**A57 Link Roads**

**TR010034**

**9.88 Applicant's comments on Deadline 11  
submissions**

May 2022

**6.4 Environmental Statement  
Figure 5.4 Air Quality EU Compliance Risk  
Assessment**

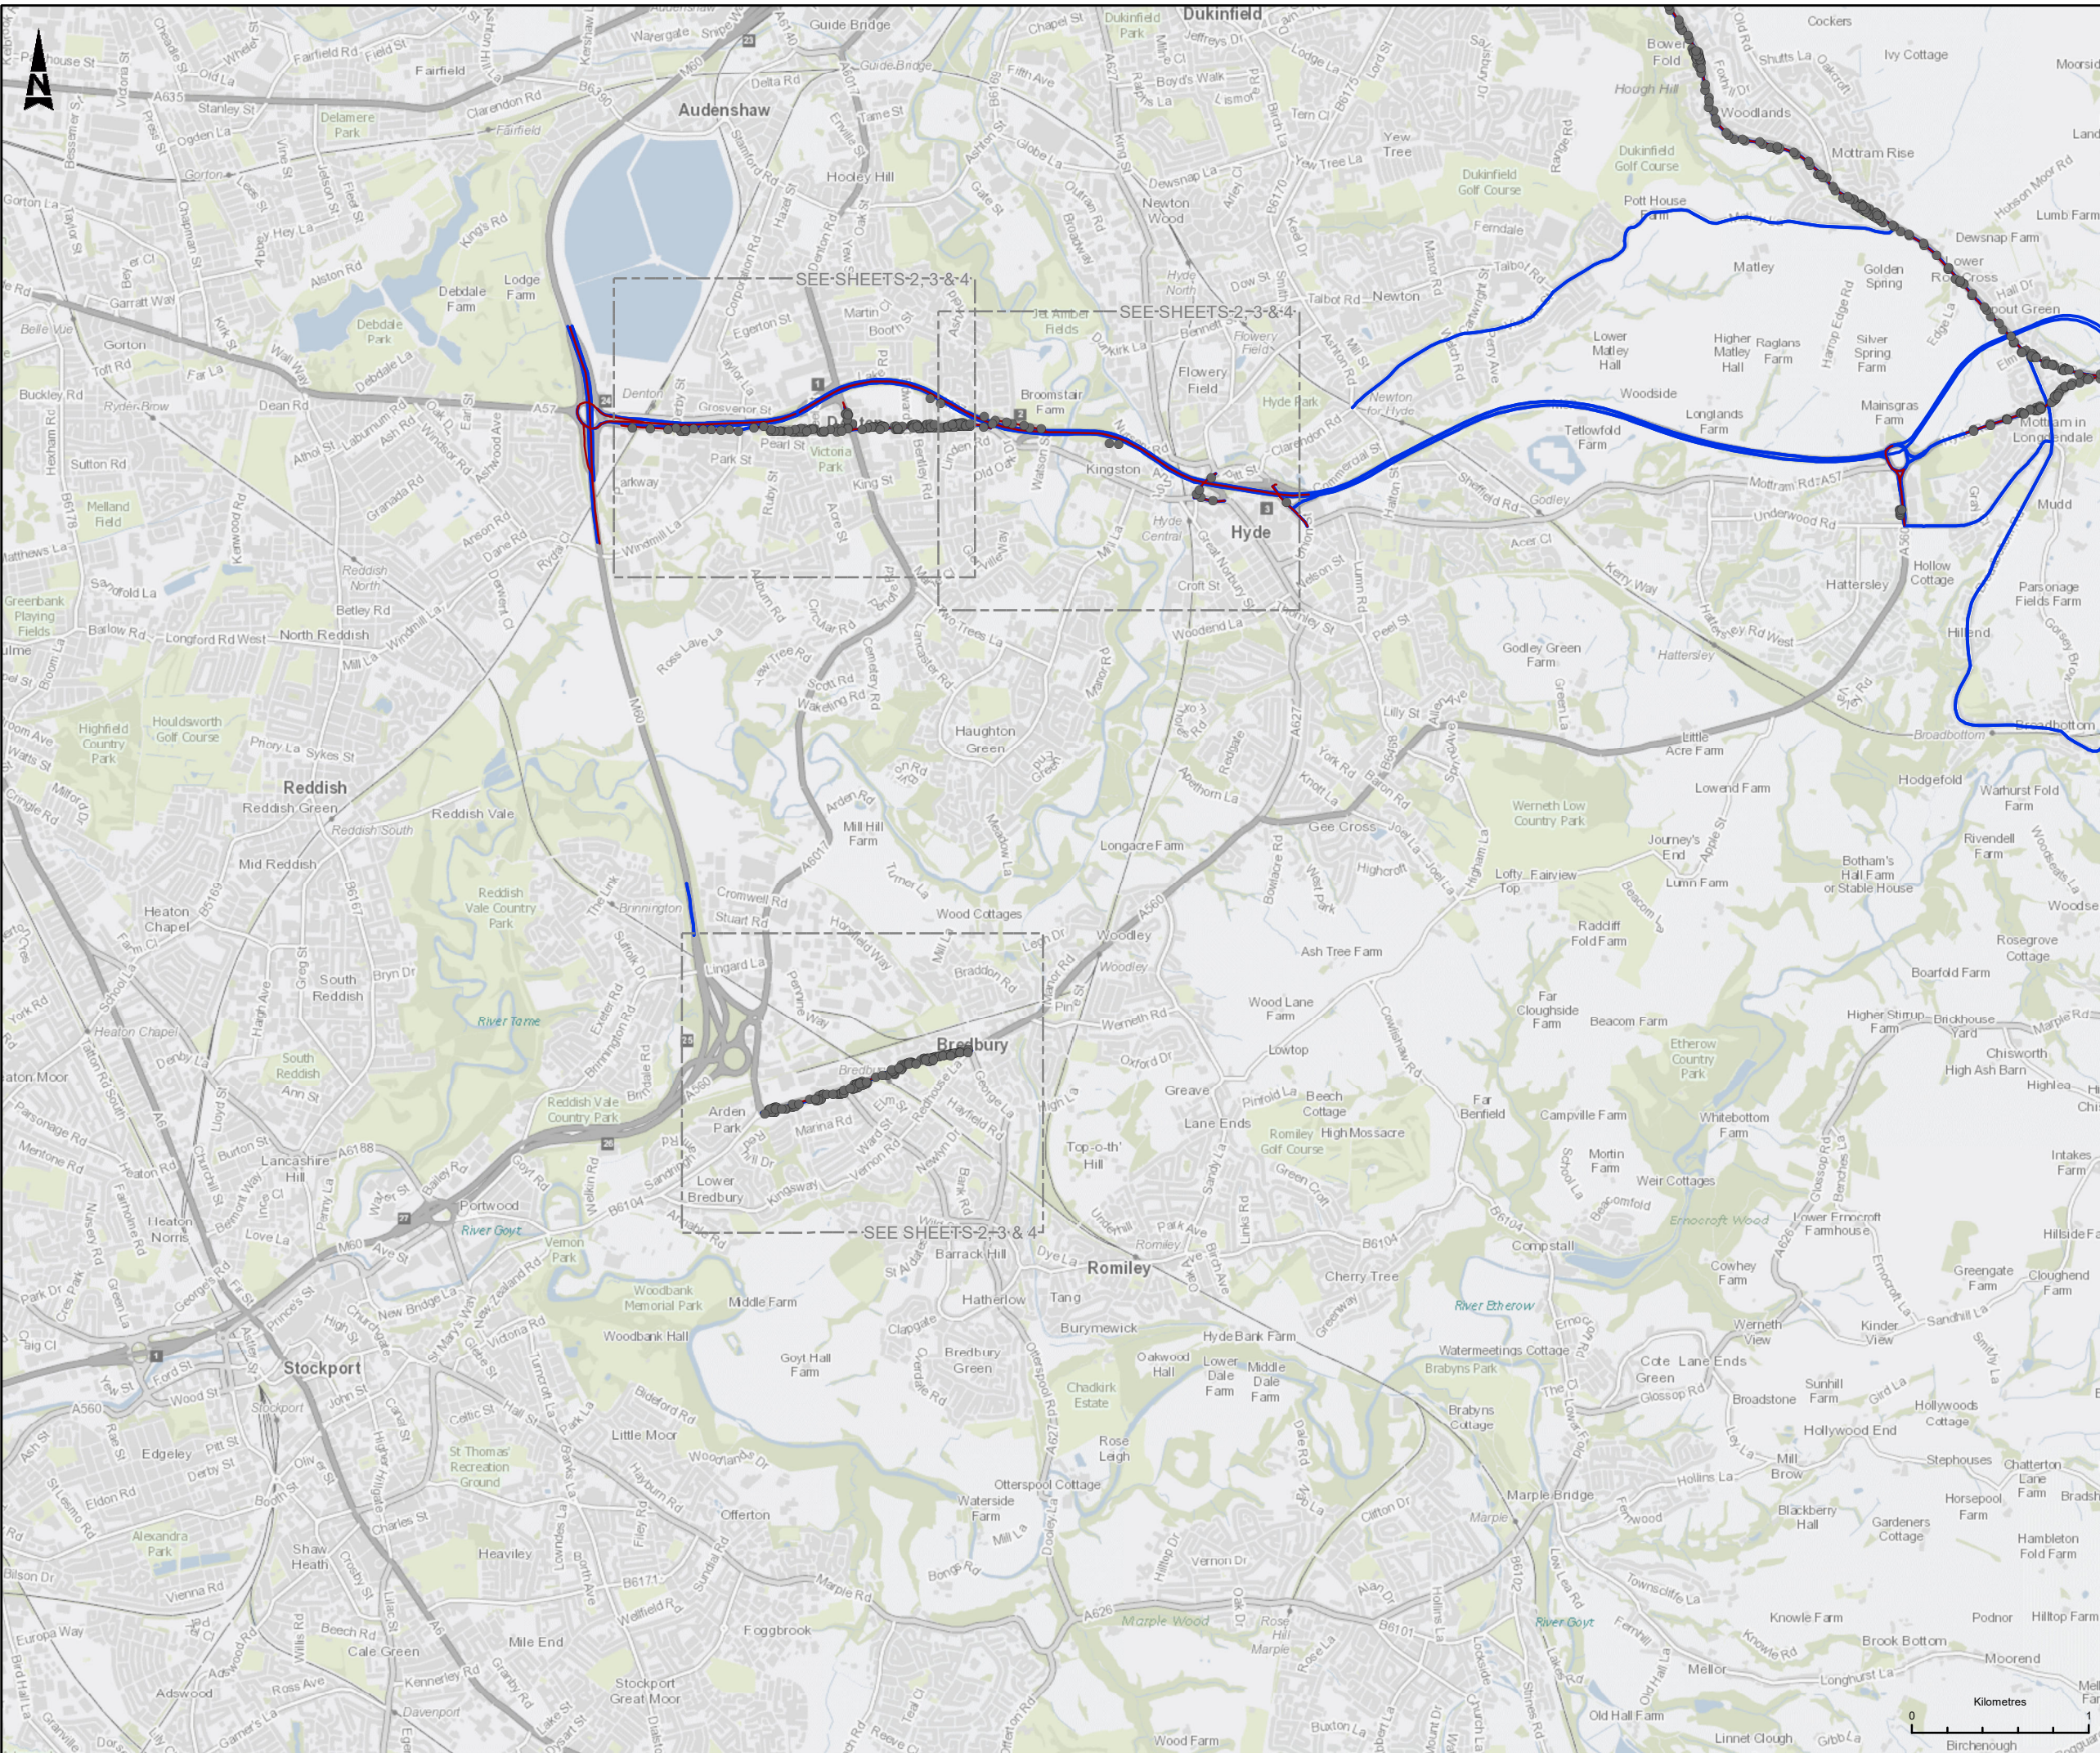
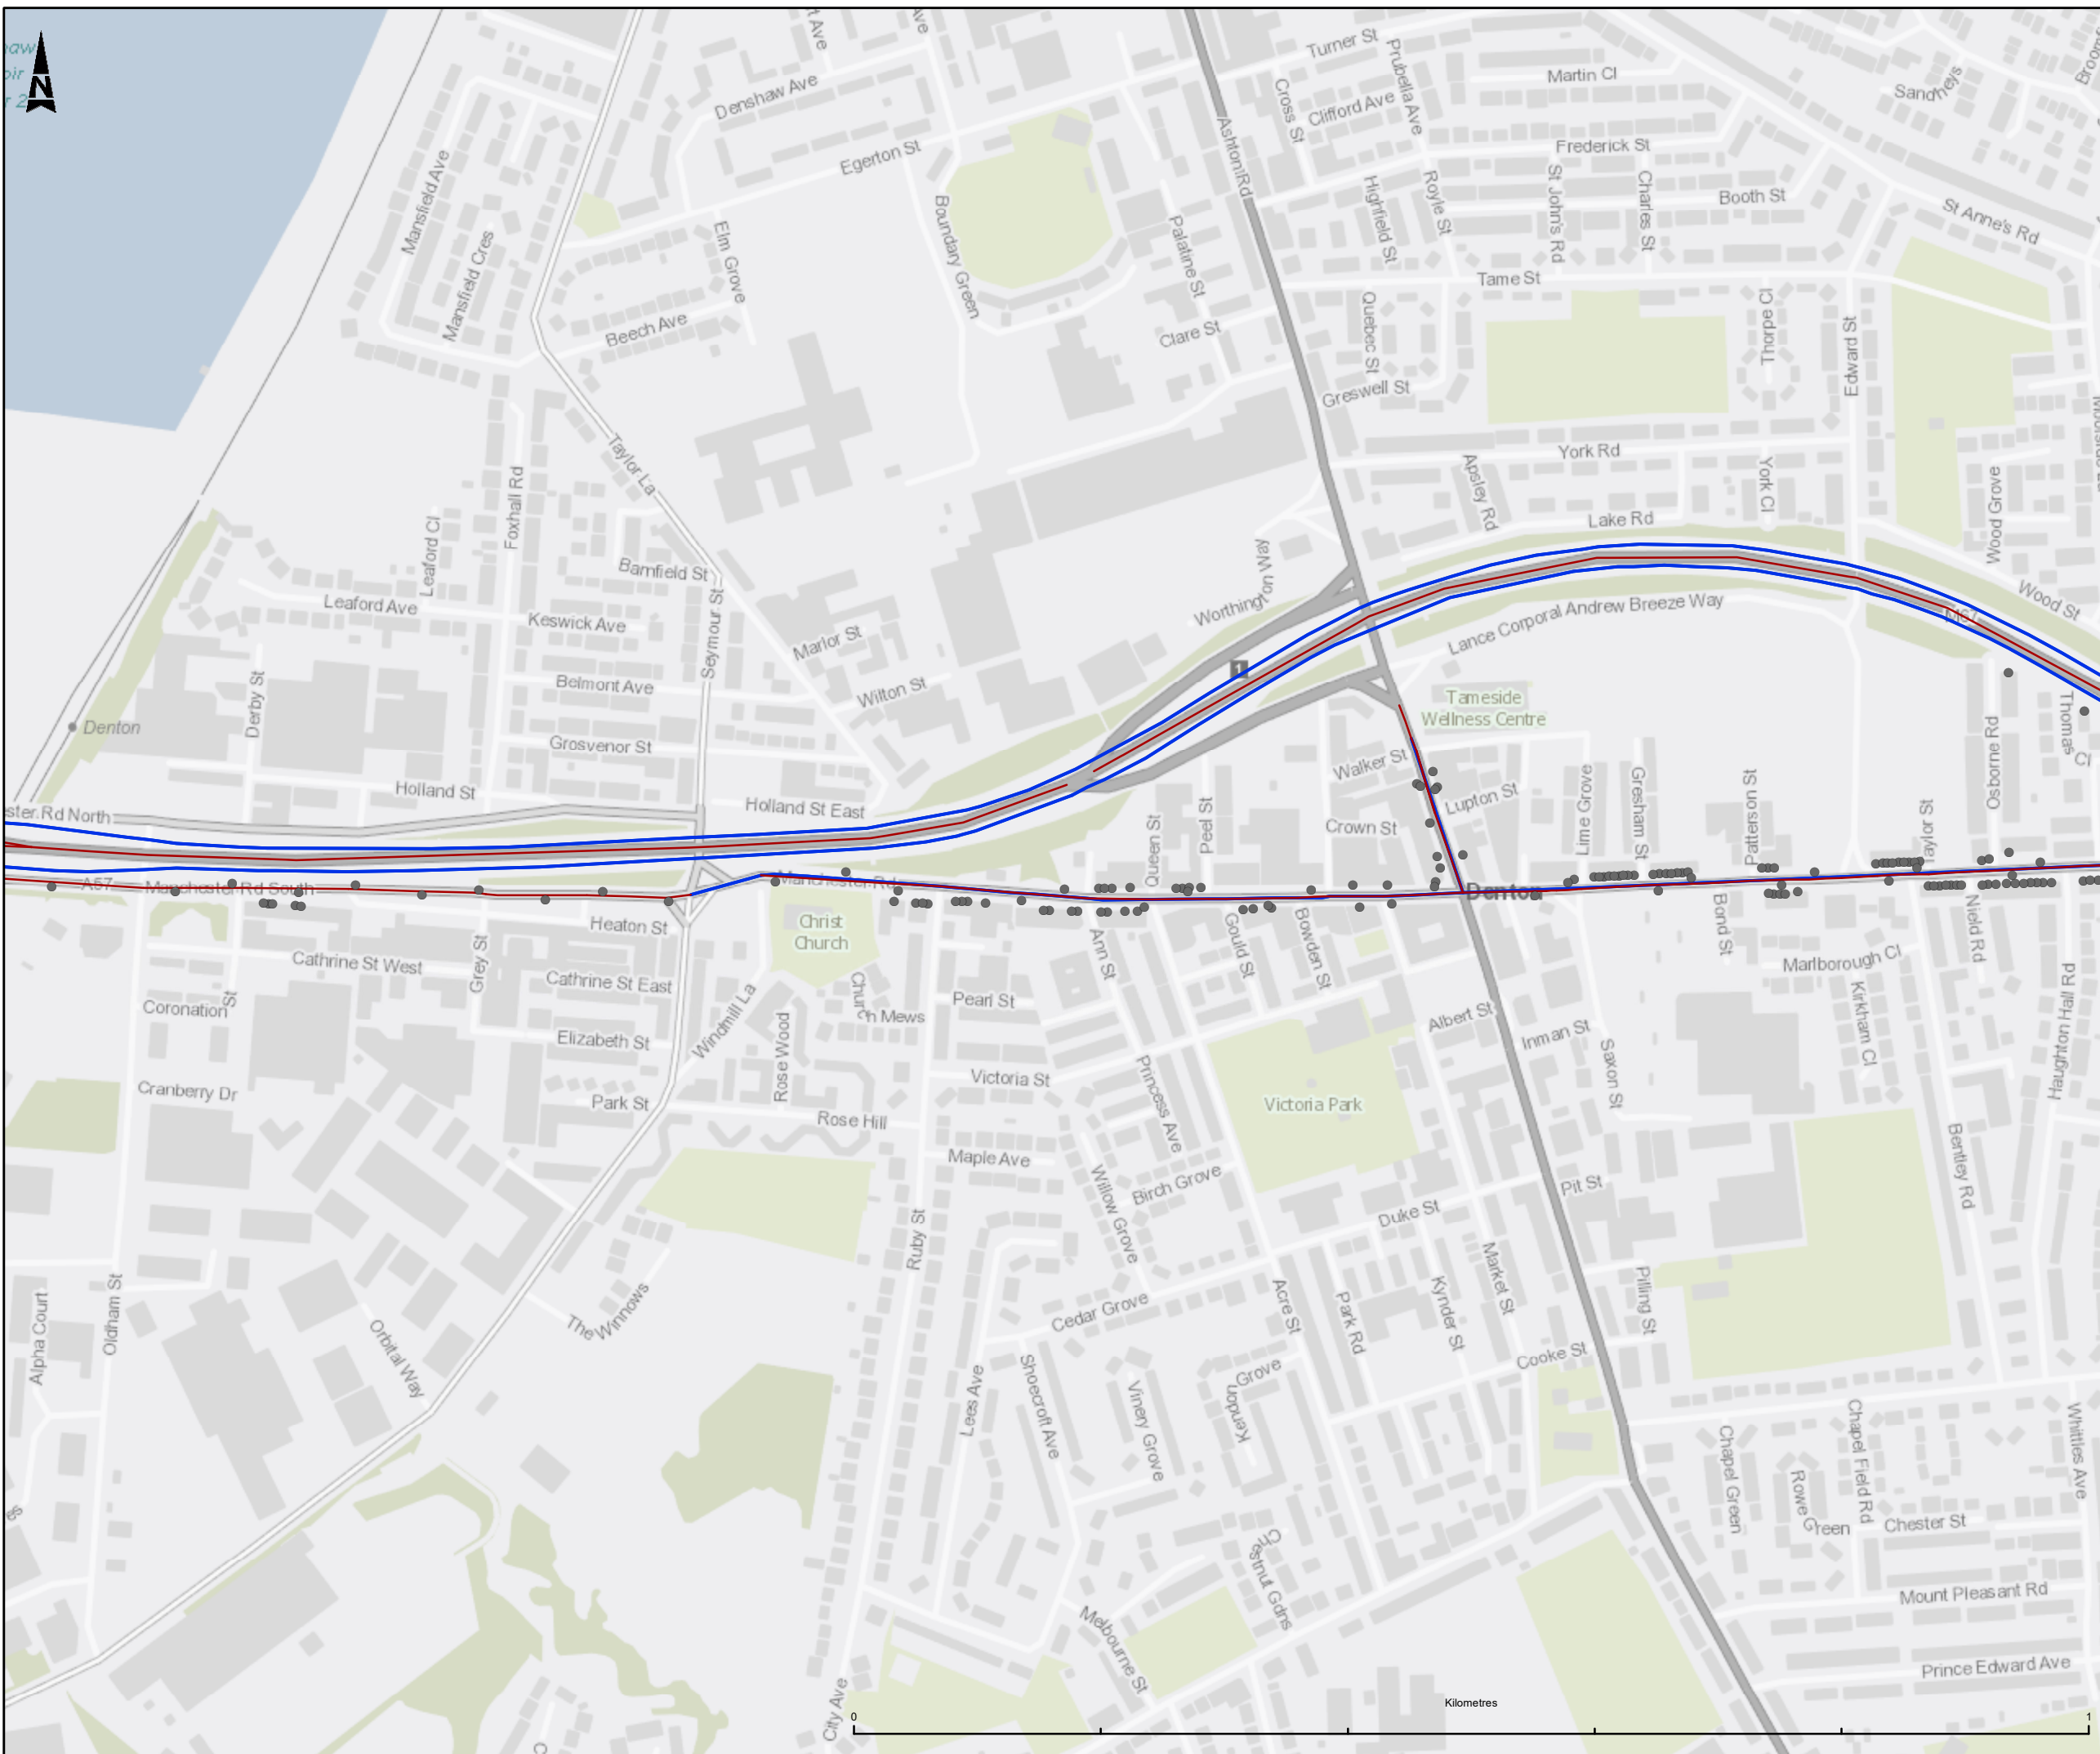
Reference	IP Issue	NH Response
9.88.4	<ul style="list-style-type: none"> <li>human health receptors on the A57 in Brookfield Identification of the receptors (figure 5.4) used in the compliance risk assessment (using LAQM “conservative” forecast”) indicated that “large” change at some of the receptors along Brookfield. However, it also highlighted that some of these were human health receptors that had not been included as receptors in the (less conservative) primary human health AQ assessment (DMRB LA 105). Therefore, HPBC have requested that these receptors are also assessed in accordance with the DMRB LA 105 . Following further discussion and clarification (virtual meeting held 8th April 2022) it was agreed that a sensitivity test will be undertaken to identify the air quality impact at relevant qualifying feature receptors located adjacent to the A57 Brookfield under the DMRB LA 105 human health assessment methodology (to be submitted by National Highways at deadline 11 – ref. TR010034/EXAM/9.86) Results from the updated air quality assessment updated DMRB LA 105 indicated a “Large increase” in NO2 DS compared to DM in 2025, at locations along Wooley Bridge with 1 location exceeding the AQO (40ug/m3) as a result of the scheme.</li> </ul>	<p>The Applicant’s position is provided in the Deadline 12 submission of the final Statement of Common Ground with High Peak Borough Council (TR010034/APP/8.3(3)). The supplementary air quality assessment for Brookfield is provided in REP11-011. It states that, [for receptors exceeding air quality standards] given the number of receptors (75 receptors) that experience a decrease in concentrations with the Scheme, it is still considered that this outweighs the one receptor with a ‘small’ increase in concentration and one receptor with a ‘large’ increase in concentration with the Scheme. Overall, as reported in the ES, the impact of the Scheme is an improvement in air quality for human health receptors and there is not a significant adverse effect due to the Scheme (paragraph 6.1.2 of REP11-011).</p>
